Rezoning Transportation Analysis

Petition Number: 2023-007

Date	Description
05-23-2023	First Review (JP)
06-21-2023	Second Review (DR)
07-10-2023	Third Review (DR)
07-26-2023	Fourth Review (PDM)

Transportation Summary

SHEET TITLE
REZONING PLAN: PETITION # 2023-007

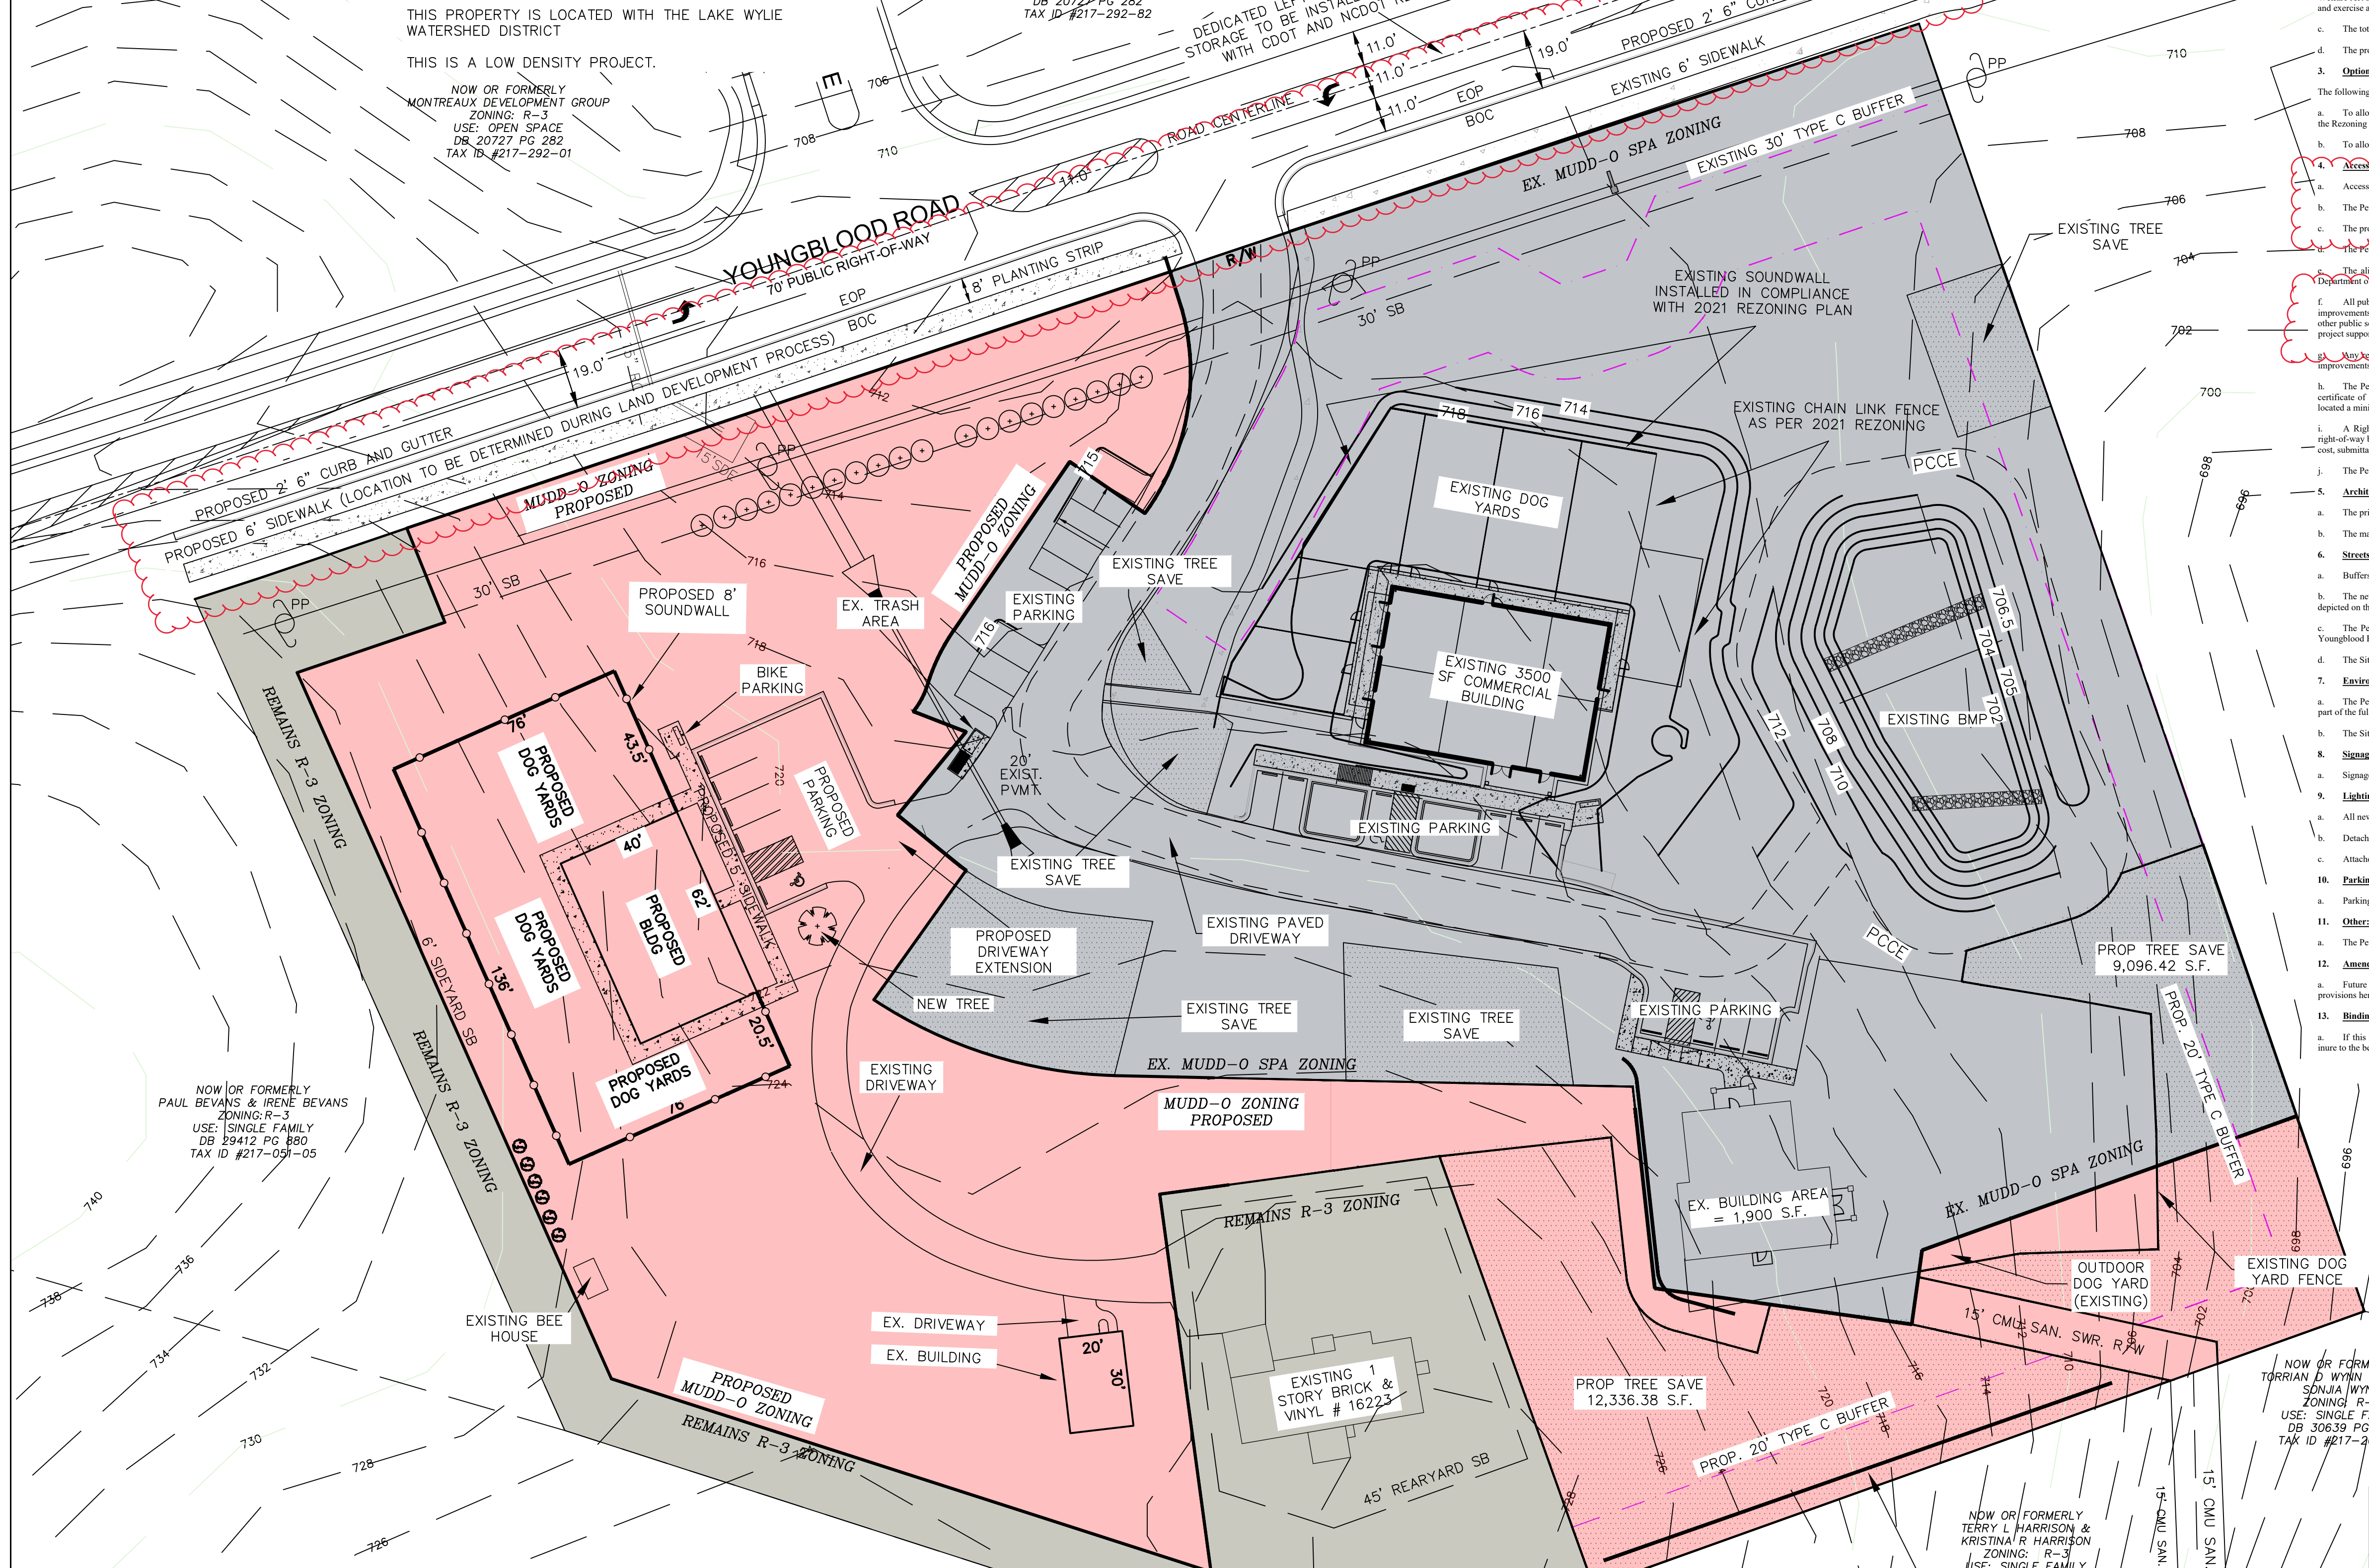
- a. ~~Youngblood Road: Location of curb and gutter to be moved to 19 feet from roadway centerline to accommodate the Charlotte Streets Map with a roadway typical section of a 2+ avenue with an 8-foot planting strip and a 12-foot multi-use path.~~

~~Label and dimension the curb and gutter from the centerline for each road on the site plan.~~

Clarifying comment 6.21.2023: Label and dimension back of curb from the roadway centerline of Youngblood Road.

~~5. Revise site plan and conditional notes to provide a minimum of 35ft of ROW to the roadway centerline of Youngblood Road if it does not exist. Label and dimension the ROW.~~

~~b. The Petitioner will re-strip Youngblood Rd. as generally depicted on the Rezoning Plan to create a westbound left turn lane with 100 feet of storage and appropriate taper from Youngblood Rd. into the Site.~~

~~10. Revise site plan and conditional note(s) to construct 8-foot planting strips and 12-foot multi-use path on Youngblood Road. The site plan shall label and dimension both items from the back of curb and gutter. Add conditional note the entire facility must be outside of the right of way and within a public access easement. Add conditional note committing to construction and maintenance of the 12-foot multi-use paths on Youngblood Road.~~
